From: Simon Davis
Sent: 23 April 2021 10:15
To: Alex Burrows [REDACTED]
Cc: Daniel Vick <Daniel.Vick@arun.gov.uk>
Subject: RE: BR/8/21/RES

Re: 224 London Road, Bognor Regis – BR/8/21/RES

From: Simon Davis <Simon.Davis@arun.gov.uk>
Sent: 08 April 2021 14:09
To: Richard Stefanski [REDACTED]
Cc: Alex Burrows [REDACTED]
Subject: RE: BR/8/21/RES

Drawing Title:
PROPOSED FLOOR PLANS

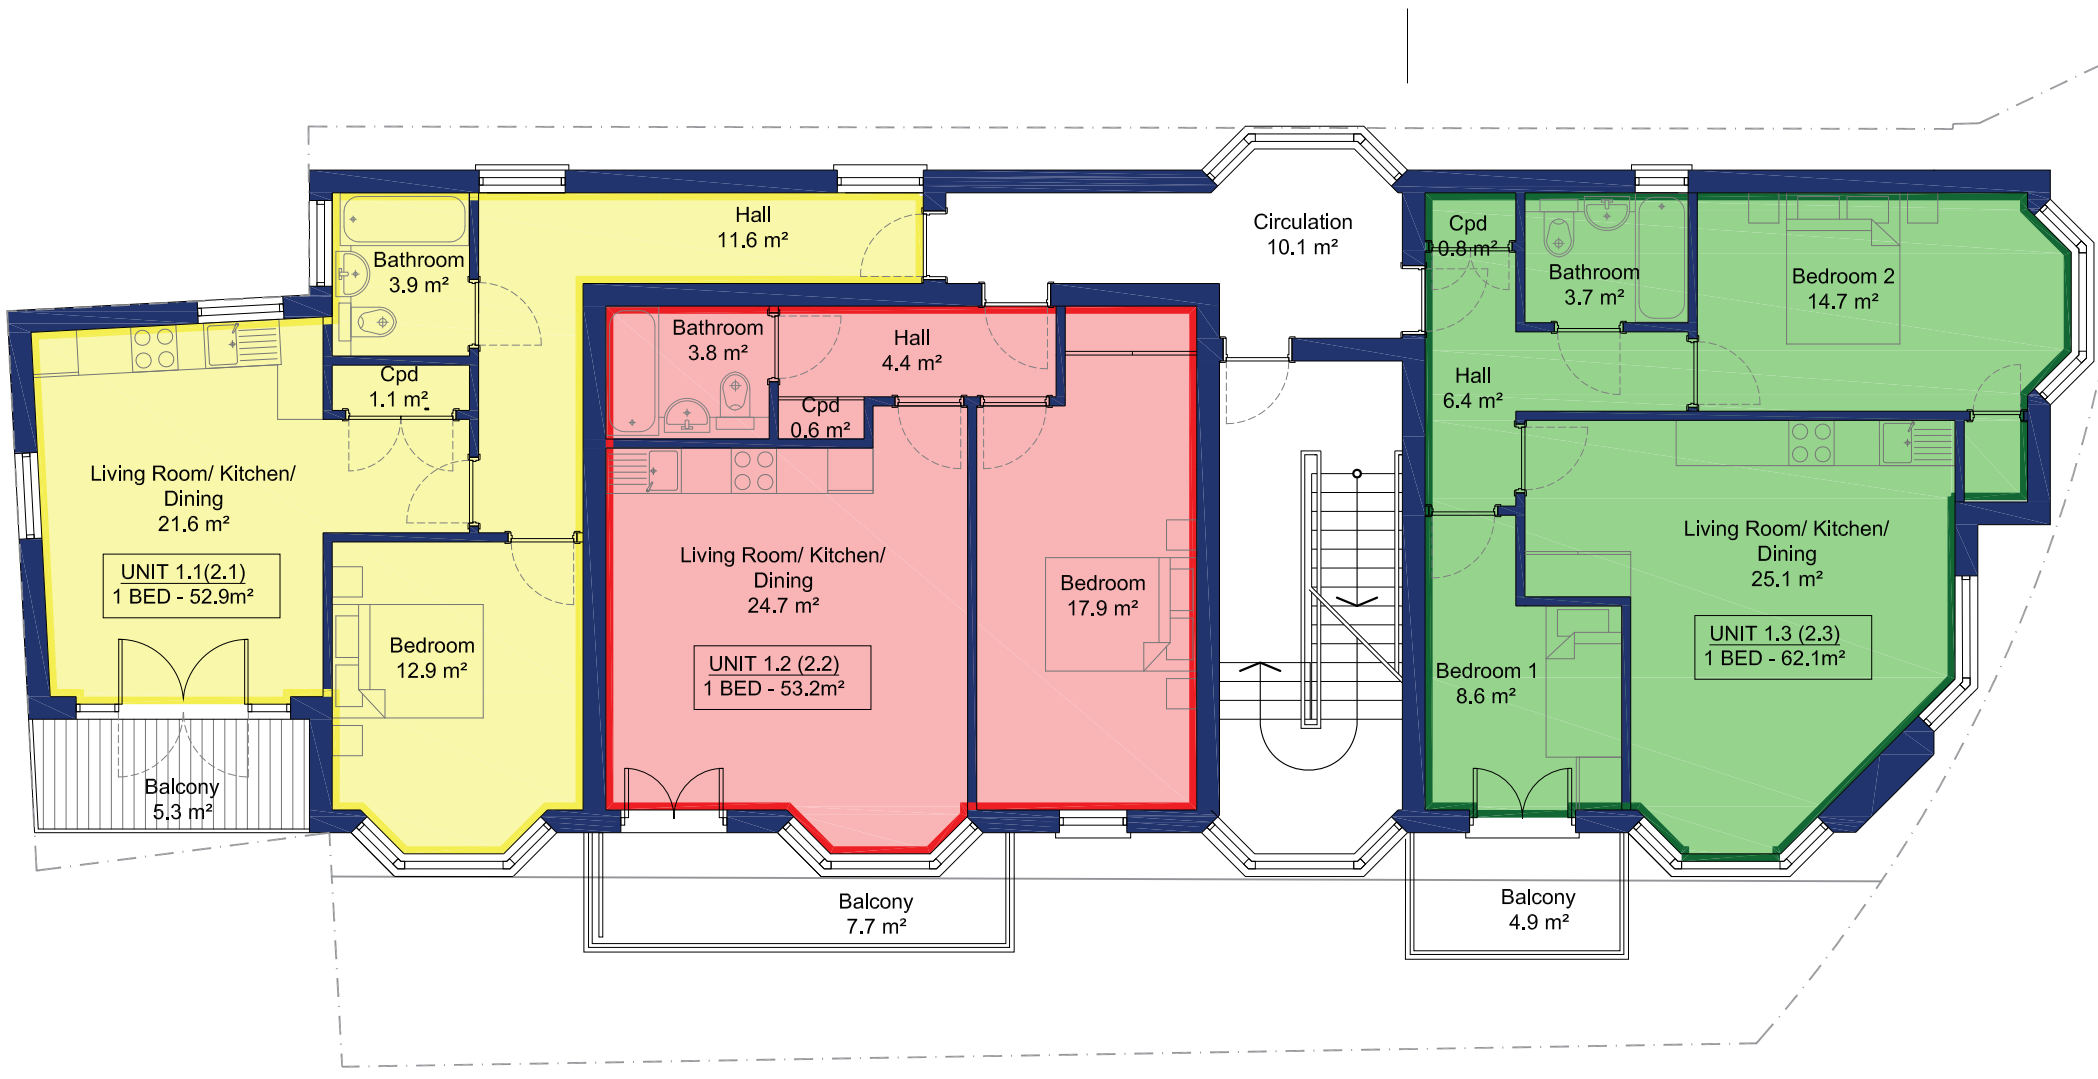
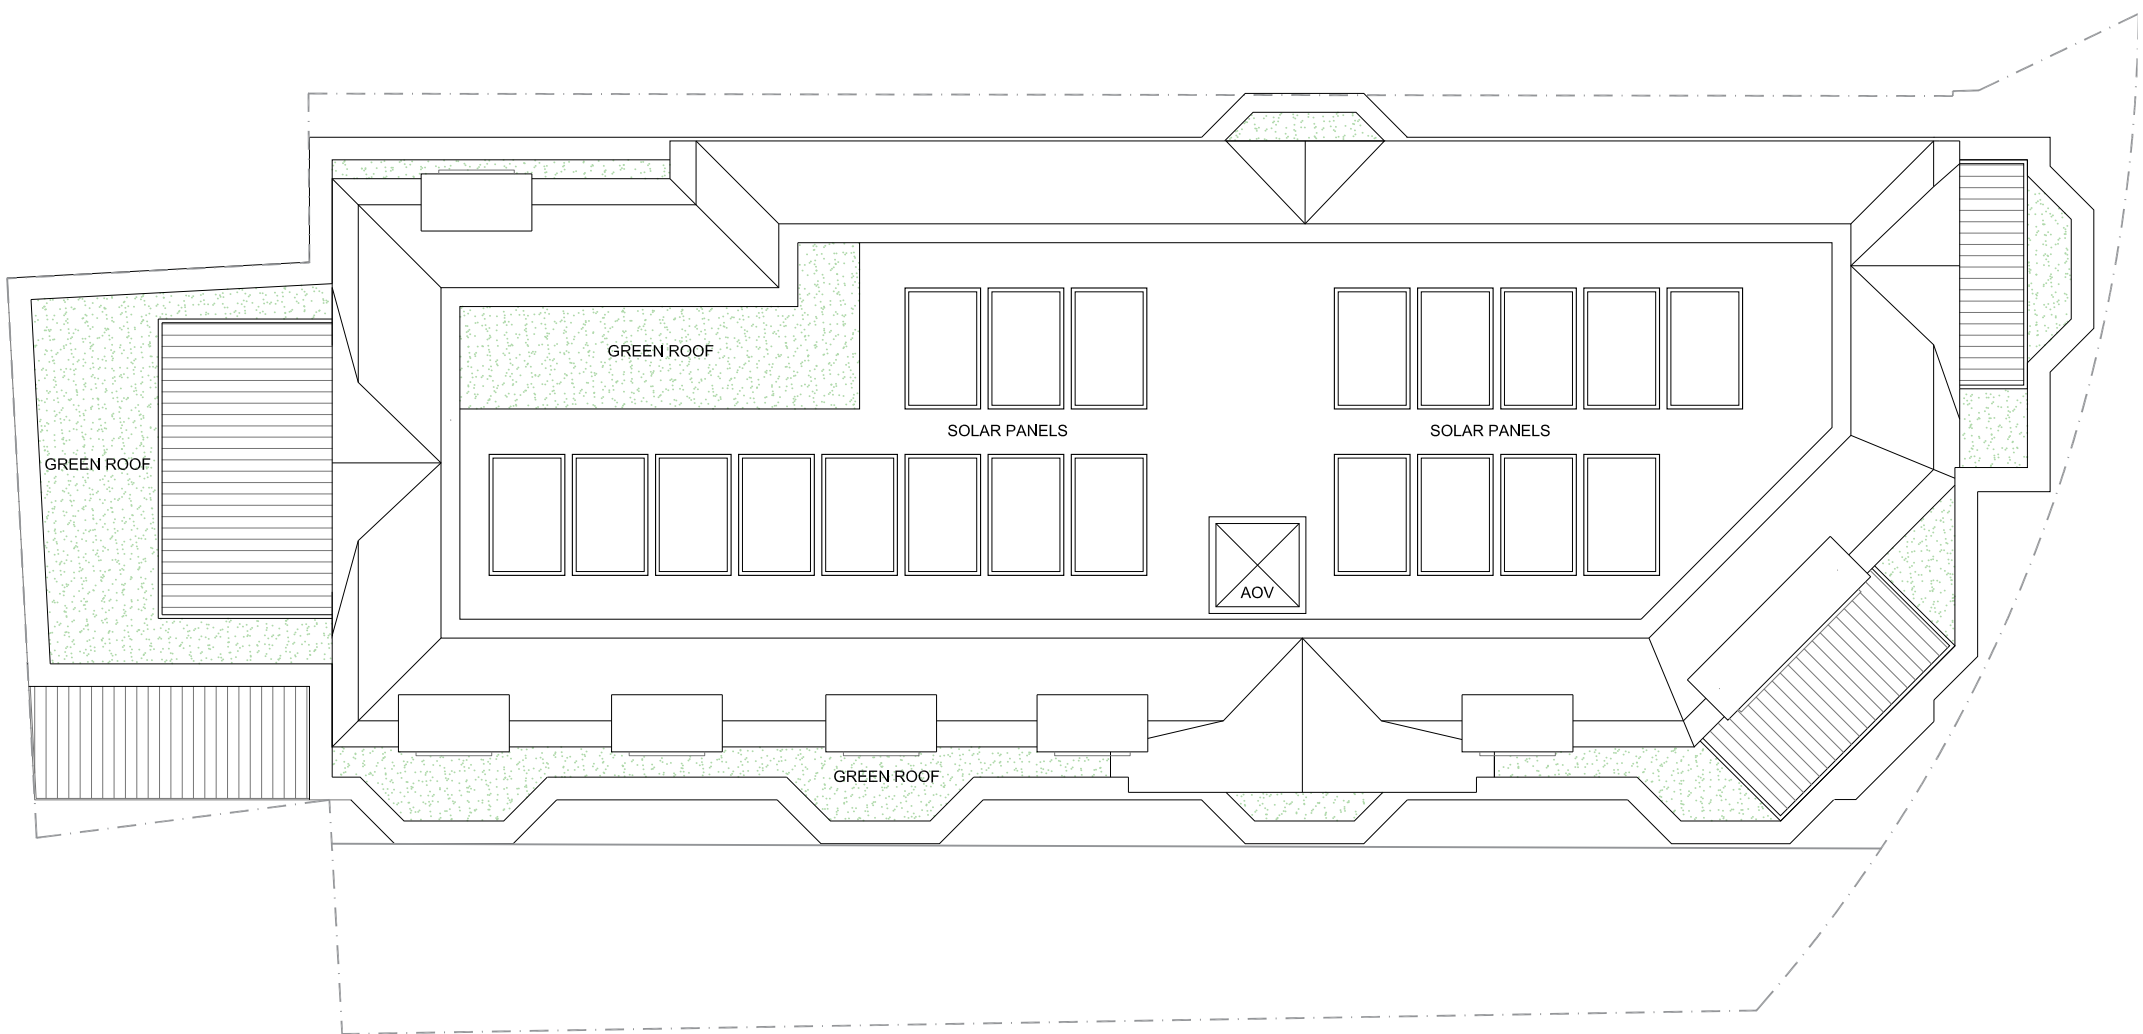
Our concern is with the height/scale and design of the proposed building. The Outline was for up to 10 flats over a max of 3.5 storeys but we did not give any indication at that time that such a scheme would be acceptable and indeed our members expressed serious concerns at Committee regarding 3.5 storeys/10 flats. We consider that the proposal will be out of character with its surroundings (noting that the predominant existing form of development is two storeys) and that the proposal could also result in harm to the two nearby heritage assets (signal box & railway bridge).

In light of your design comments we have made significant alterations to the plans to reduce the overall height and scale of the proposal to reduce any possible impact on the adjacent heritage assets. The height has been reduced by 1m and the overall width of the building has been reduced by in excess of 3m.
